Australian Institute of Architects

30 March 2020

To: Department of Planning, Industry and Environment (DPIE) / Reference Western Harbour Tunnel & Warringah Freeway Upgrade EIS Application Number SSI-8863

FIGURE 4.11 - CAMMERAY GOLF COURSE - CONCEPT MASTERPLAN

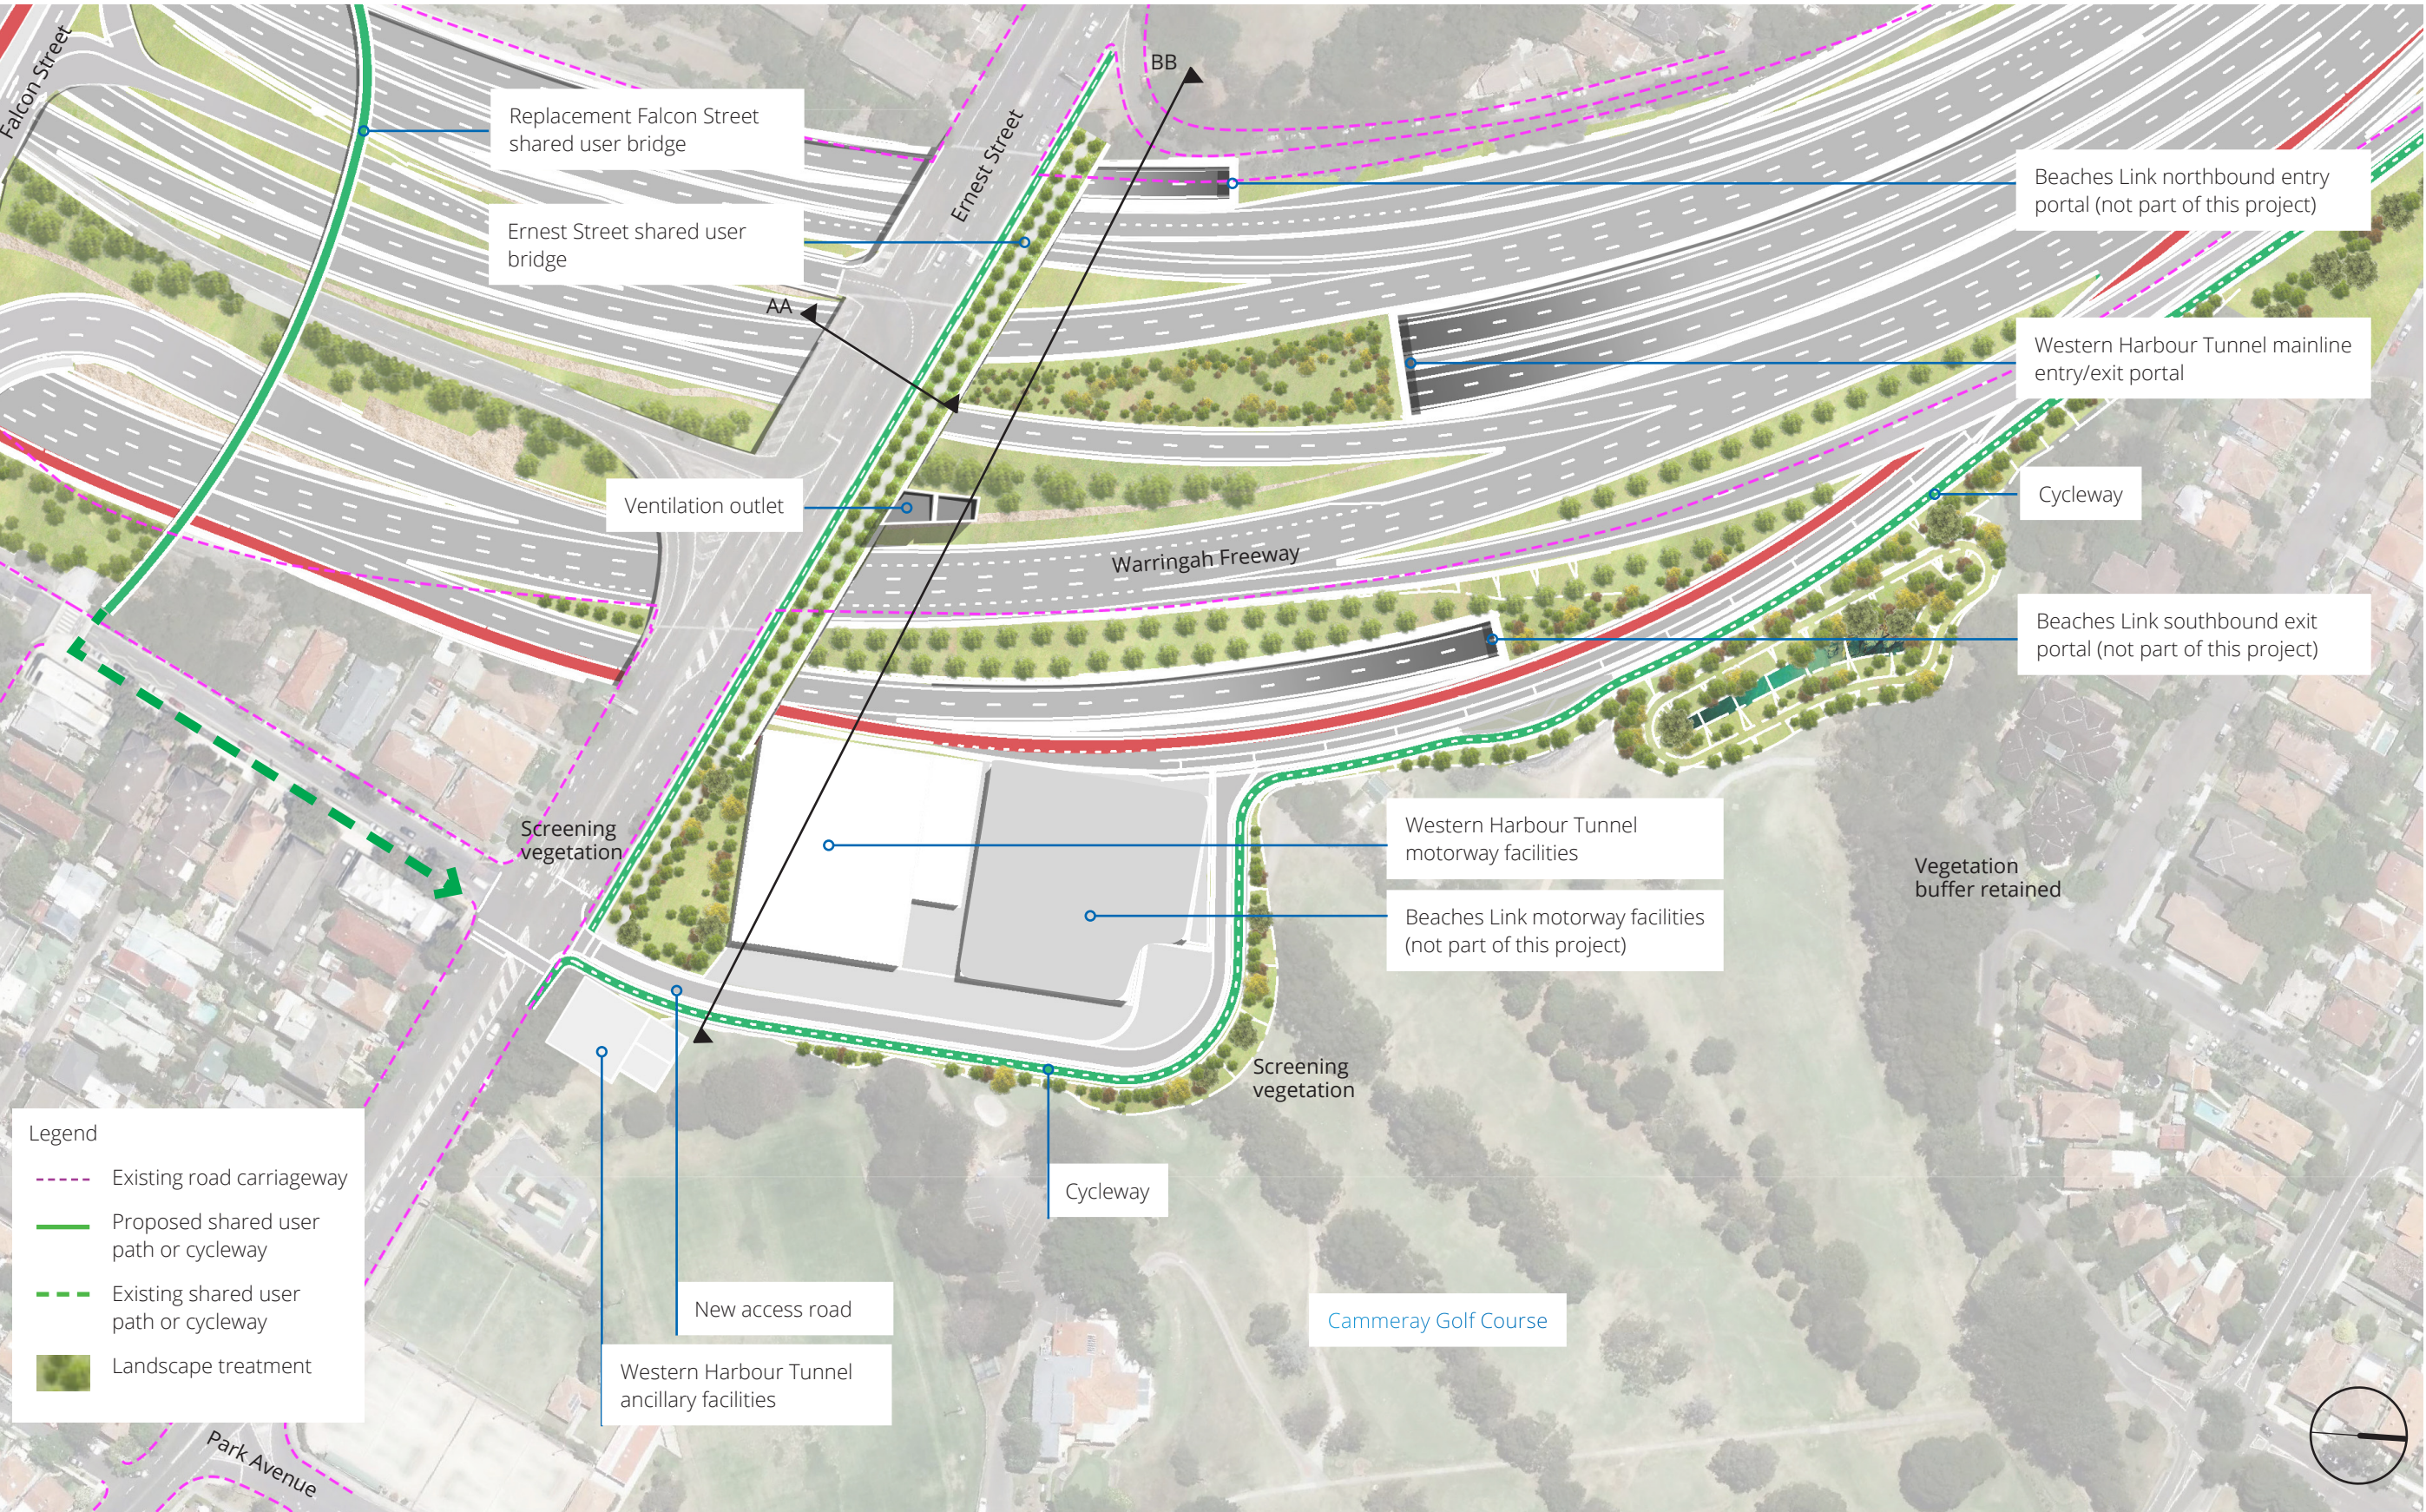
Problem: The proposal is for the loss of more than 26,000m² of public recreation space in Cammeray Park. Under the current design this would be permanently replaced with the large sheds for the control centre and the motorway itself.

- Permanently reduce public recreation space by more than 26,000 m²
- Erect two large industrial sheds in the area which had been parkland
- Enlarge the separation between the parks from 200m to 330 metres
- Sever the pedestrian path that crosses Cammeray Park and golf links between Ernest Street and Warringah Road
- Remove the lake in Cammeray Park.

1. There should an increase in the total area of useable green space in North Sydney as a result of the project
2. Changes to the green space in North Sydney that result from the project should be better connected and of a higher quality than would be the case without the project
3. A design investigation should be undertaken to discover the best option to meet the conditions above.
